21st September 2021

Application No.: 21/01630/OUT

Proposal: Outline planning application for residential development (within Use Class C3), open space provision, access, drainage and all associated works and operations including but not limited to demolition, earthworks, and engineering operations, with the details of appearance, landscaping, layout and scale reserved for later determination

Location: Land at North West Bicester
Home Farm, Lower Farm and SGR2
Caversfield

CLIENT: Firethorn  
 PROJECT: North West Bicester  
 DRAWING: Illustrative masterplan  
 PROJECT NUMBER: I192  
 DRAWING NUMBER: SK004 CHECKED BY: MI/LA  
 REVISION: C STATUS: Draft  
 DATE: 14/04/2021 SCALE: 1:2,000

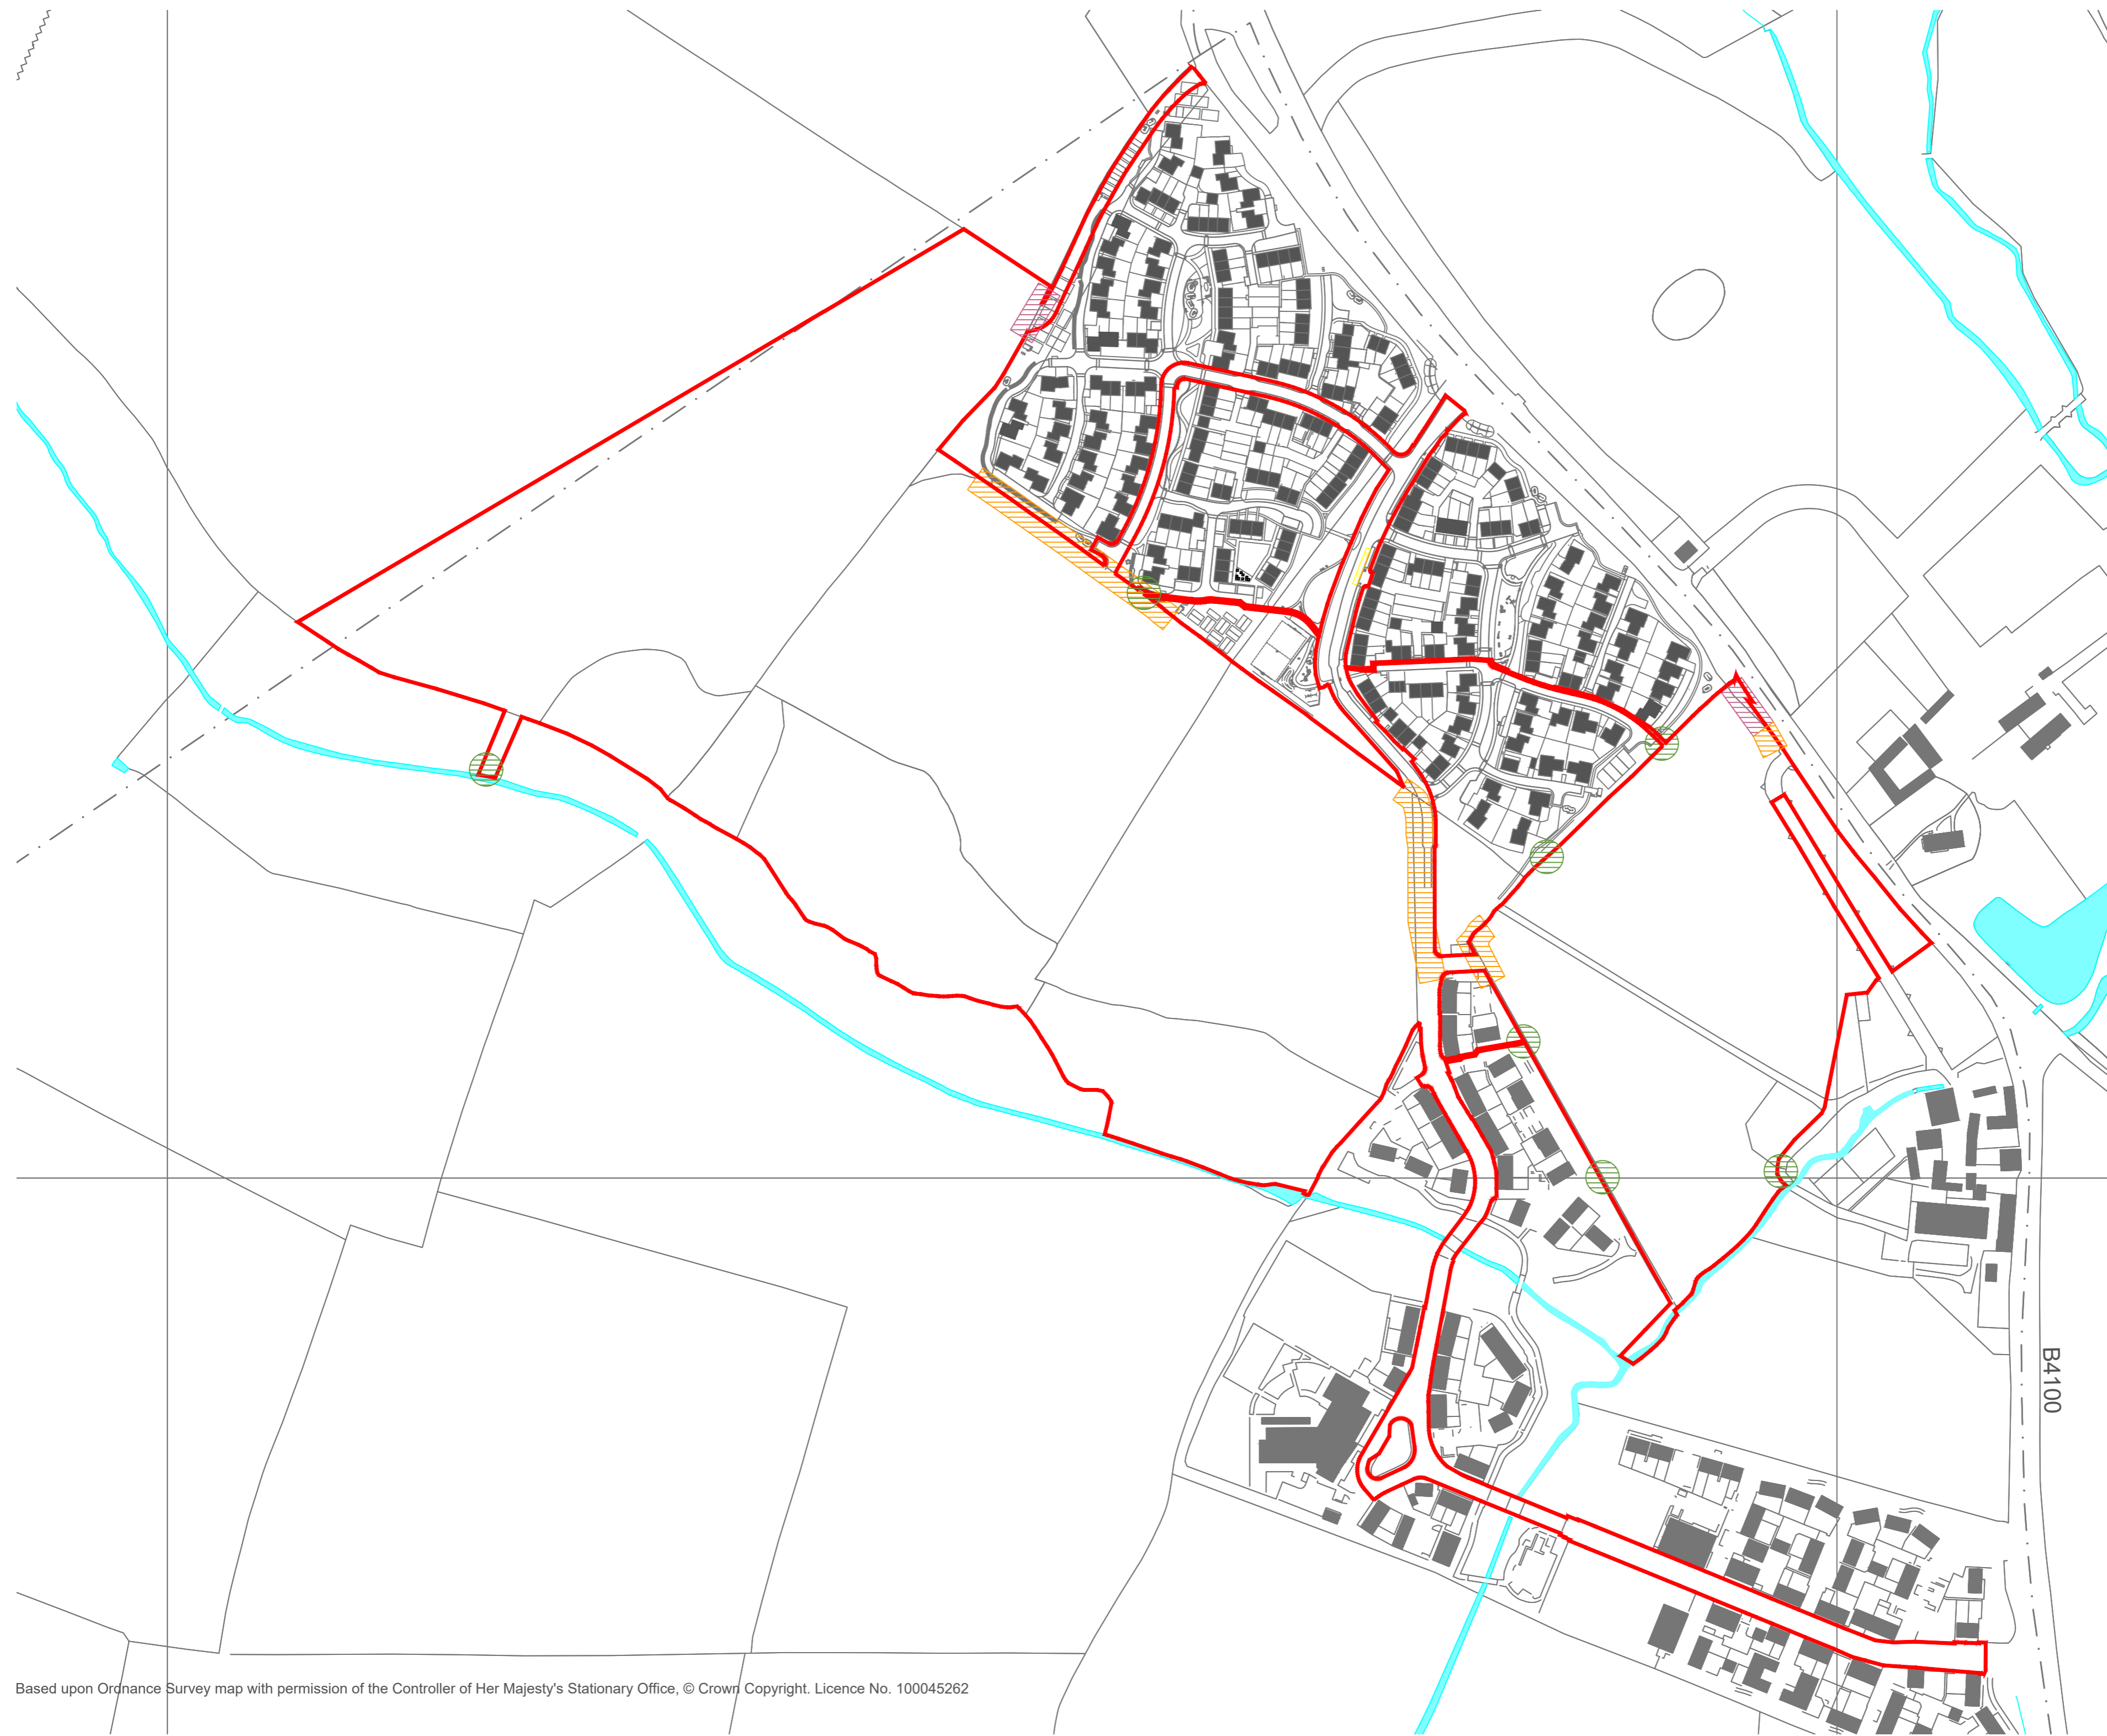
I am concerned regarding the maximum building heights parameter which identifies that there is an area of the site where 16m development would be permissible (please note there is an erroneous reference to 20m heights on page 25 of the DAS). In my opinion this is too high. This part of the NW Bicester site is more peripheral and an area of the site where you would expect to see less height (whilst it is located adjacent to the existing bus only route, it is not within an area that forms a clear 'core/ spine' to the wider site). I have also compared this to the proposals for this area of the site previously within application 14/01384/OUT (11m) and those emerging on the site to the south now subject to 21/03040/SCOP, where maximum residential building heights are likely to be proposed at around 12.5m and I believe that 16m in this area will be too high. I would recommend that the maximum building height be restricted to no more than 14m in this area.

I would also appreciate clarity on the levels marked '90m' on the Maximum Building Heights and Footprint parameter plan. If these are proposed as plateaus to be created from where building heights would be taken from, then I have concern with this in terms of the level of earthworks required to create these in some areas and also the impact of this level upon nearby residential units approved on Elmsbrook (Phase 2 particularly – the levels were approved by application 16/00044/DISC). My main concern relates to the southern areas of the site where the land drops towards the water courses. Some broad information on likely development levels would be helpful to assist in the assessment of maximum heights as it is noted that finished floor levels may vary by + or – 2m (detailed level information can be sought via planning condition but where a parameter plan is being proposed, then it is important that the judgement of the maximum heights that can be accommodated is made in the context of knowing the likely land level). In addition, the impact of significant earthworks (should they be proposed) may need assessment via the Environmental Statement as well as possible impacts arising from that. Cross sections in a few areas as identified below (and to the north) could assist the assessment of this:

The Plan should be amended to remove the reference to 90m or be updated if this is the case to ensure absolute clarity.

I have some concerns that the parameter plans themselves should be amended to show consistency with each other. For example, the building heights and footprint parameter plan shows built form on areas that cannot be built on according to the Green Space parameter plan – such as the heritage enhancement zone, the multi functional green space areas and the hedgerows and their buffers etc. I think that those areas need to be accounted for – this could either be through a single parameter plan (given the scale of the site) or, through a series as you currently have, but which take into account the constraints of each other.
